M42 Junction 6 Development Consent Order

8.12 Statement of Common Ground with The Woodland Trust

STATEMENT OF COMMON GROUND
The Woodland Trust

Drawing Title  
**FIGURE 8.3 PROPOSED LANDSCAPE PLANTING SHEET 1 OF 3**

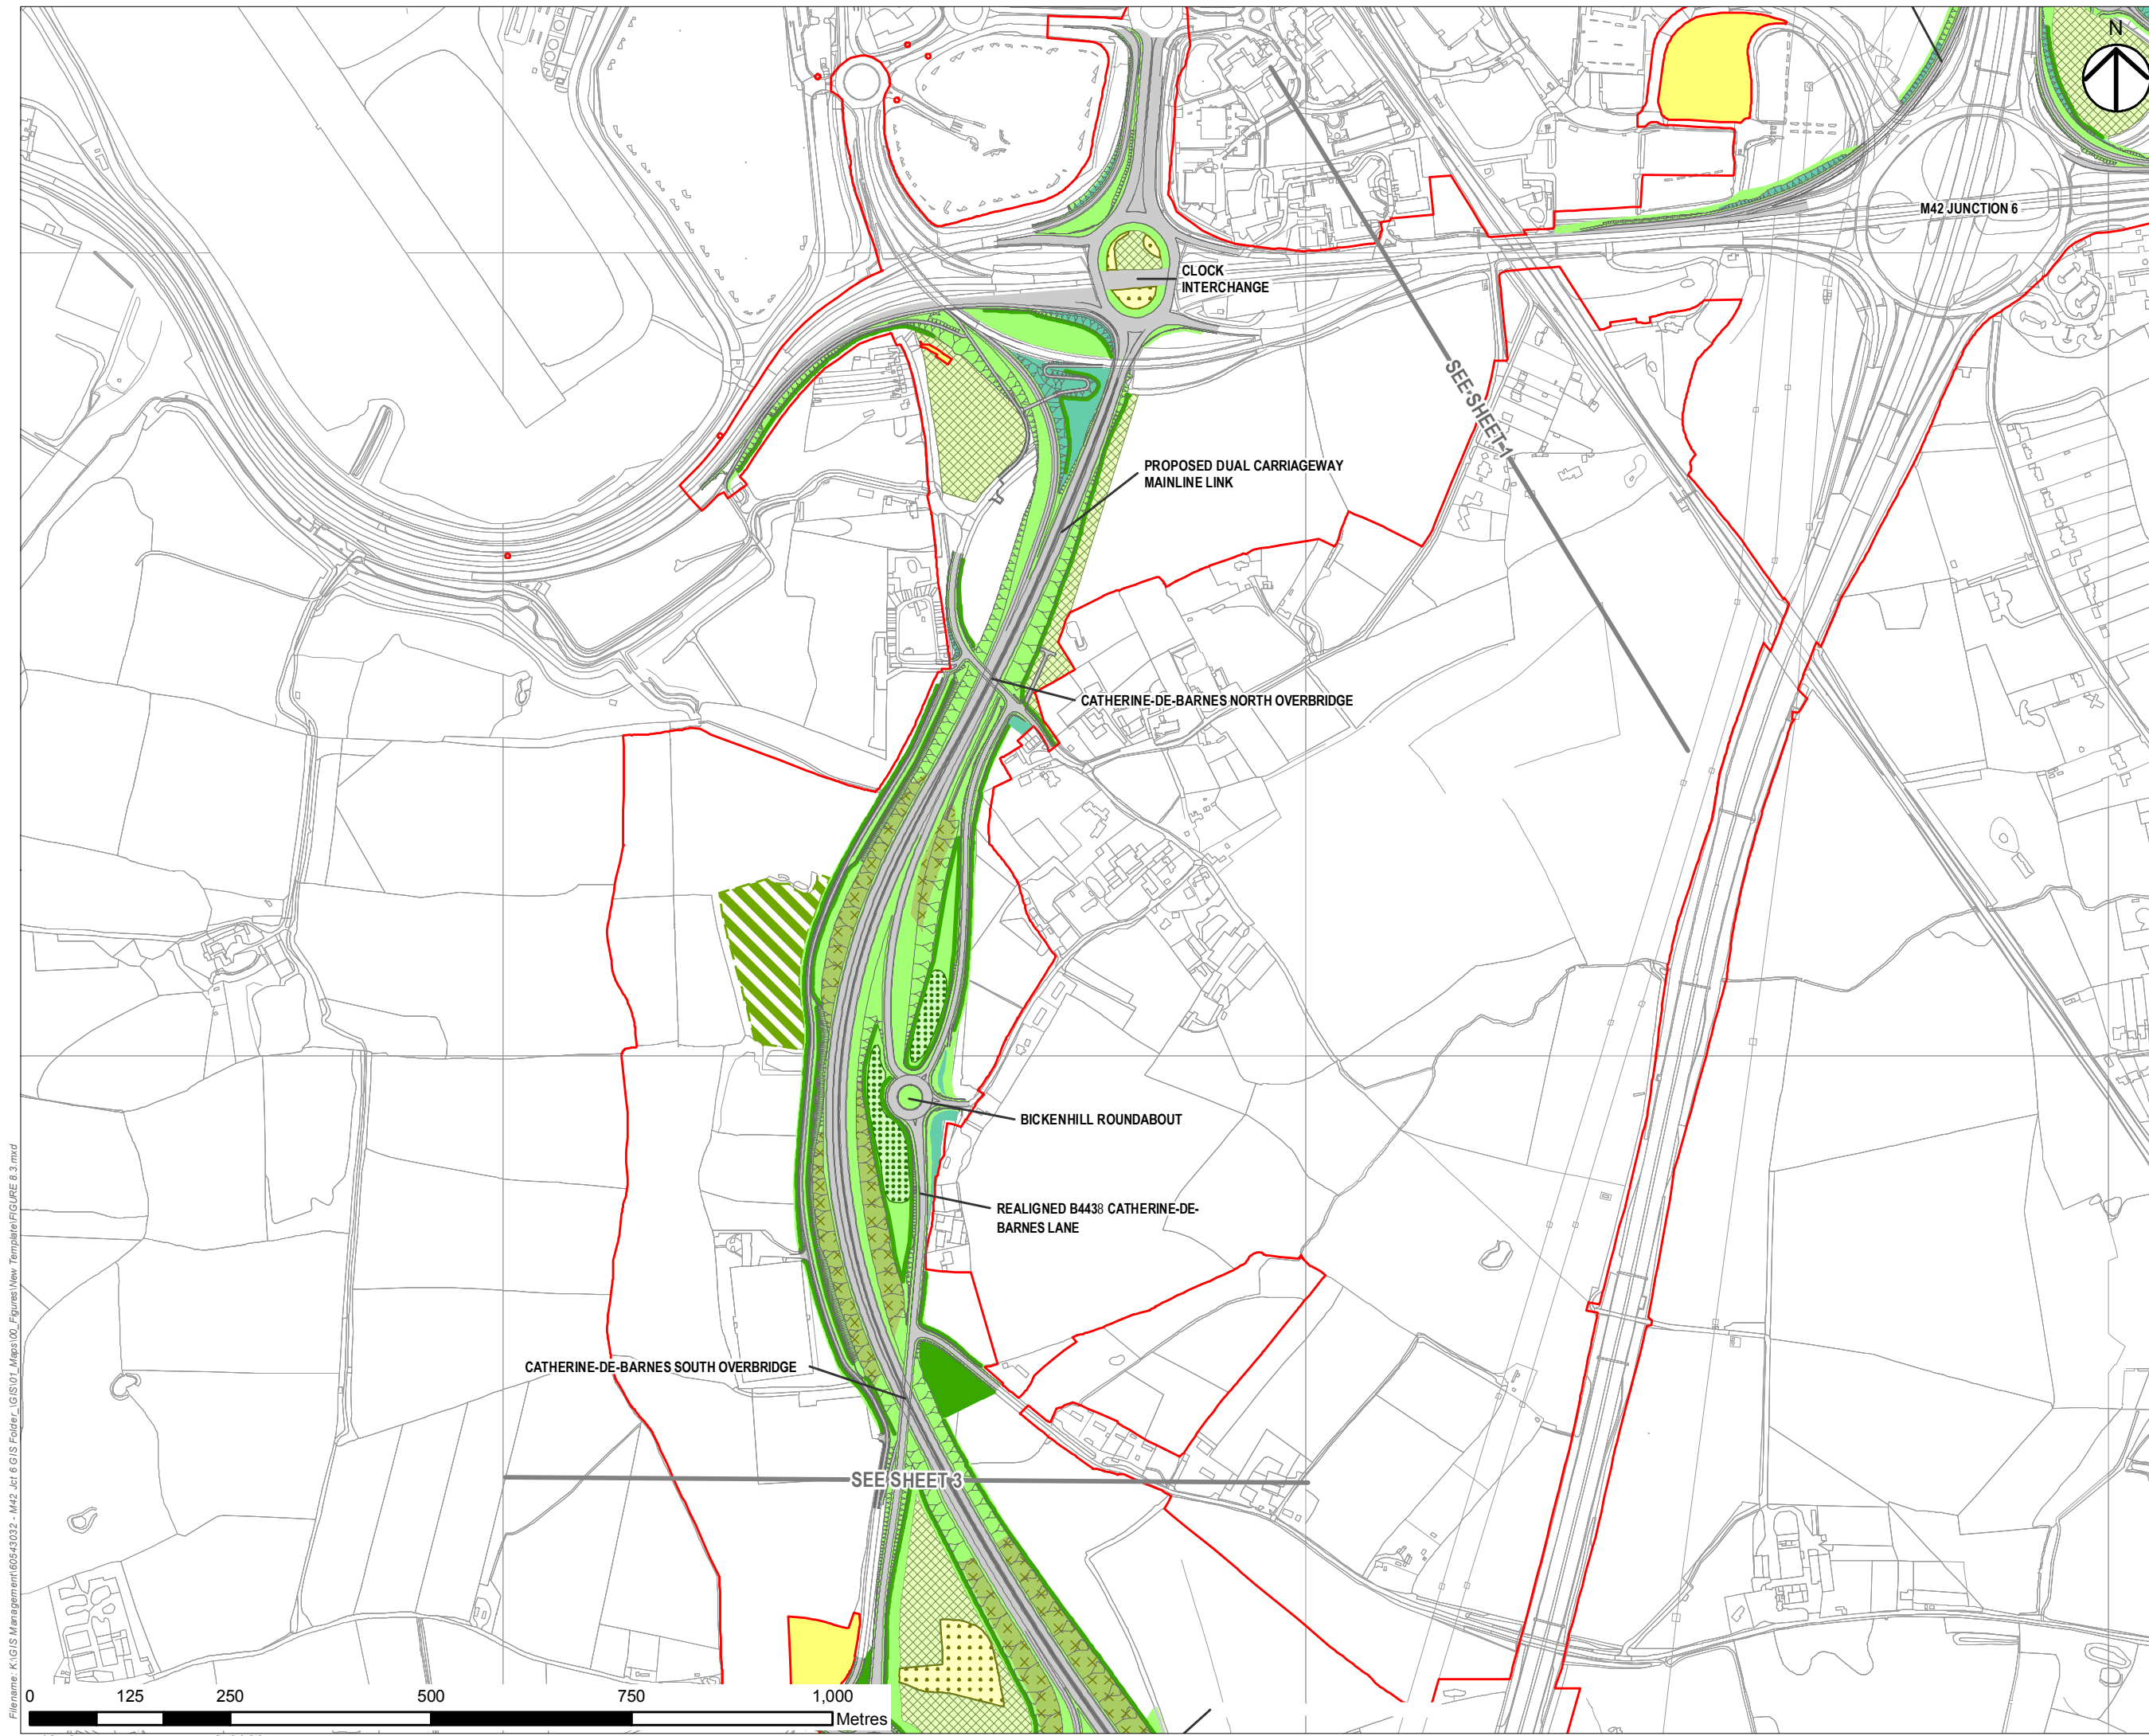
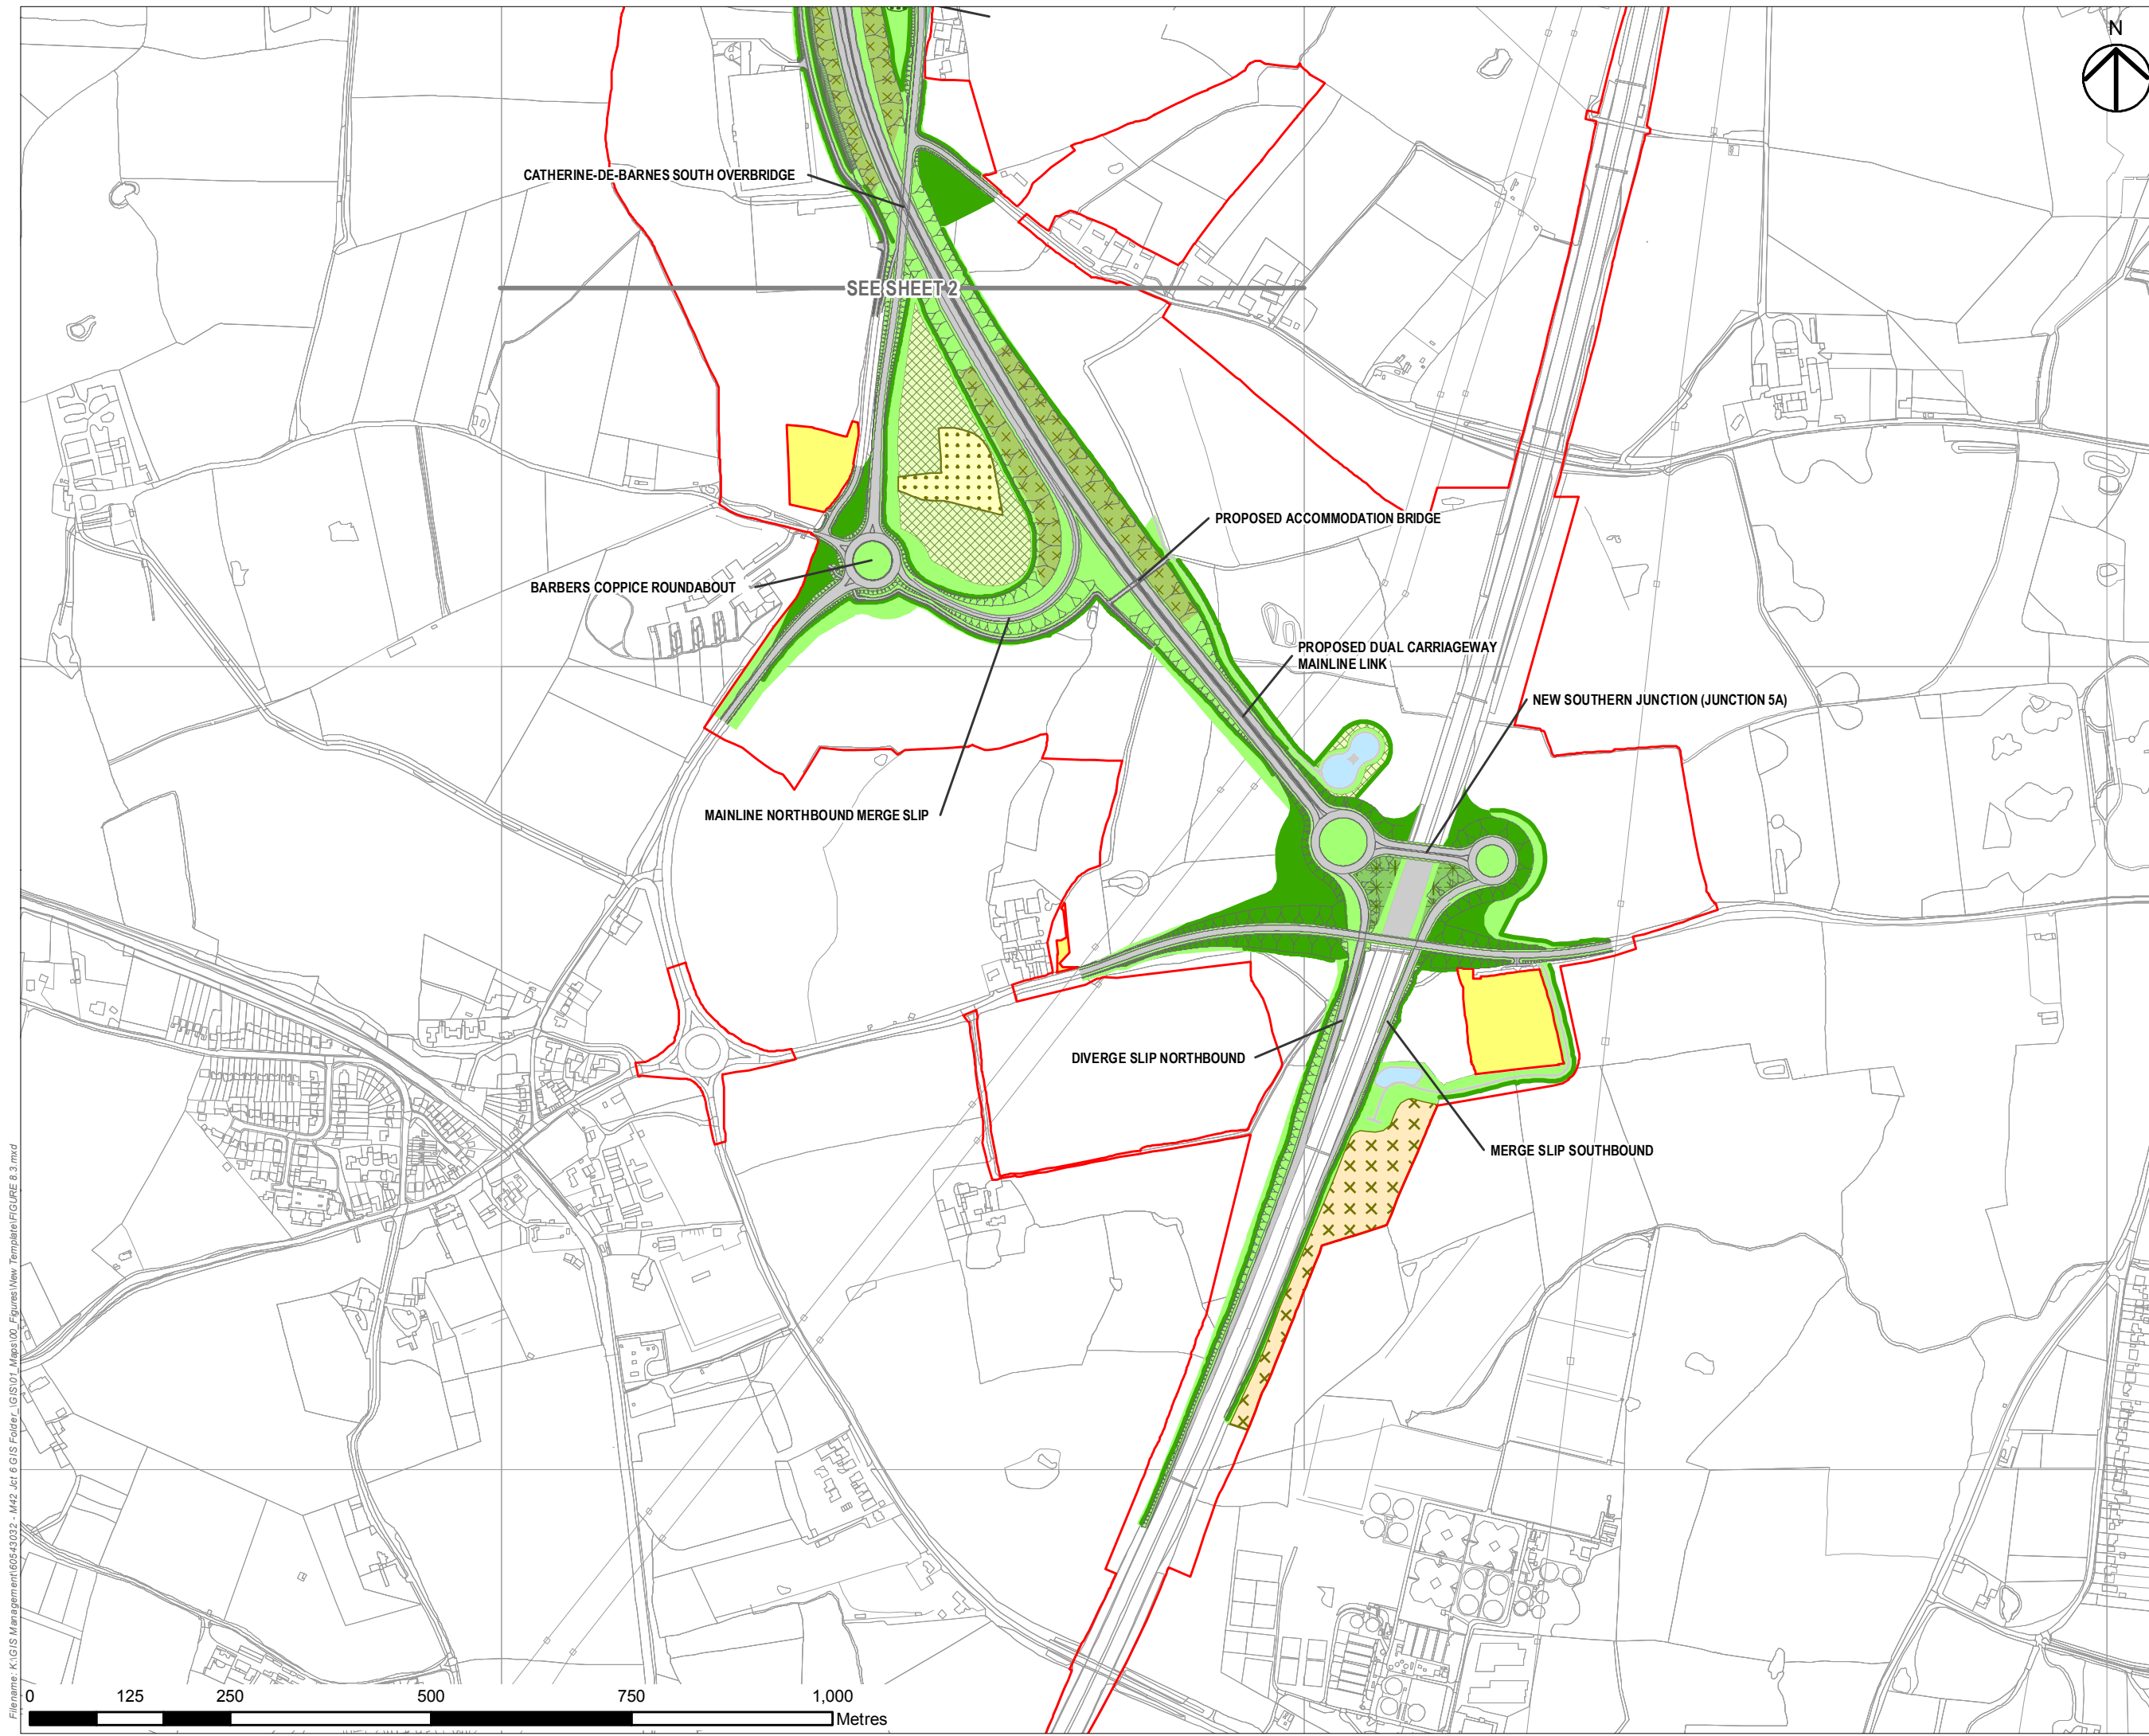
Sub-topic	The Woodland Trust Comment	Highways England Response/Actions	Status/Agreement
<p>Aspbury’s Copse Ancient Woodland</p>	<p>The Woodland Trust accepts soil translocation as a last resort form of compensation in relation to ancient woodland loss within the DCO application, and for soils to be moved to a recipient site. However, such “translocation” is not considered as avoiding or minimising the loss; it can only be viewed as a “salvage” operation seeking to move components of a complex habitat, when loss of woodland is inevitable, as part of a compensation package.</p>	<p>Highways England agree that the use of soil translocation to an area of compensation planting for the loss of ancient woodland at Aspbury’s Copse in addition to a range of management and monitoring commitments.</p>	<p>Agreed</p>
	<p>The Woodland Trust stated that methodology regarding the siting of the compensation planting area and the soil translocation which have been previously agreed with Natural England would be acknowledged by the Woodland Trust given Natural England’s position as the statutory environmental body for such matters. However, we do not support ancient woodland translocation on principle that we are opposed to development which</p>	<p>Noted</p>	<p>Agreed</p>

Sub-topic	The Woodland Trust Comment	Highways England Response/Actions	Status/Agreement
	<p>results in the degradation or destruction of ancient woodland</p>		
	<p>The proposed improvements will result in direct loss of Aspbury's Copse, which is designated as a Plantation on Ancient Woodland Site (PAWS) on Natural England's Ancient Woodland Inventory.</p> <p>The woodland borders both sides of the existing M42, so the improvements will result in further loss to an irreplaceable habitat.</p> <p>In summary, the Woodland Trust objects to the proposed development on the grounds of impact to irreplaceable ancient woodland.</p>	<p>Highways England have sought to continually refine the design with the aim to minimise the overall environmental impacts of the Scheme. The impact to Aspbury's Copse would be 0.46 ha of a total 2.27ha of ancient woodland resource.</p> <p>The location for Junction 5A and the adjoining slip roads and changes to Solihull Road (B4428) overbridge have been influenced by Highways England's obligation to design and construct schemes with customer safety being a primary objective. As such, the slip roads and Junction 5A have been located to allow for safe entry and exit of the junction onto and off the mainline M42 whilst working within the acceptable parameters of weaving lengths between the existing junctions (Junction 5 to Junction 6) along this section of the M42.</p>	<p>Not agreed.</p>

Sub-topic	The Woodland Trust Comment	Highways England Response/Actions	Status/Agreement
<p>Compensatory planting</p>	<p>Ancient woodland is an irreplaceable habitat, so by definition it cannot be compensated for. For all developments resulting in ancient woodland loss, the Woodland Trust asks for a 30:1 planting ratio to reflect the biological importance that an area of ancient woodland provides to the wider landscape.</p>	<p>Highways England have committed to an approximate 1.9 ha parcel of land to the immediate south of the eastern parcel of the existing ancient woodland for the compensation planting associated with the loss of Aspbury's Copse ancient woodland.</p> <p>Within this 1.9 ha planting would be at a ratio of no less than 3:1, with the area being maximized to its fullest potential for compensation planting. Highways England consider that this ratio is proportionate for the impact identified.</p>	<p>Not agreed</p>

<p>Soil translocation monitoring</p>	<p>The Woodland Trust asks that for any soil translocation compensation, the site is monitored for a minimum of 50 years. This is in line with other Development for Transport projects such as High Speed 2.</p>	<p>Highways England are working with stakeholders to agree a monitoring programme for the compensation planting associated with Aspbury's Copse.</p>	<p>Under Discussion</p>
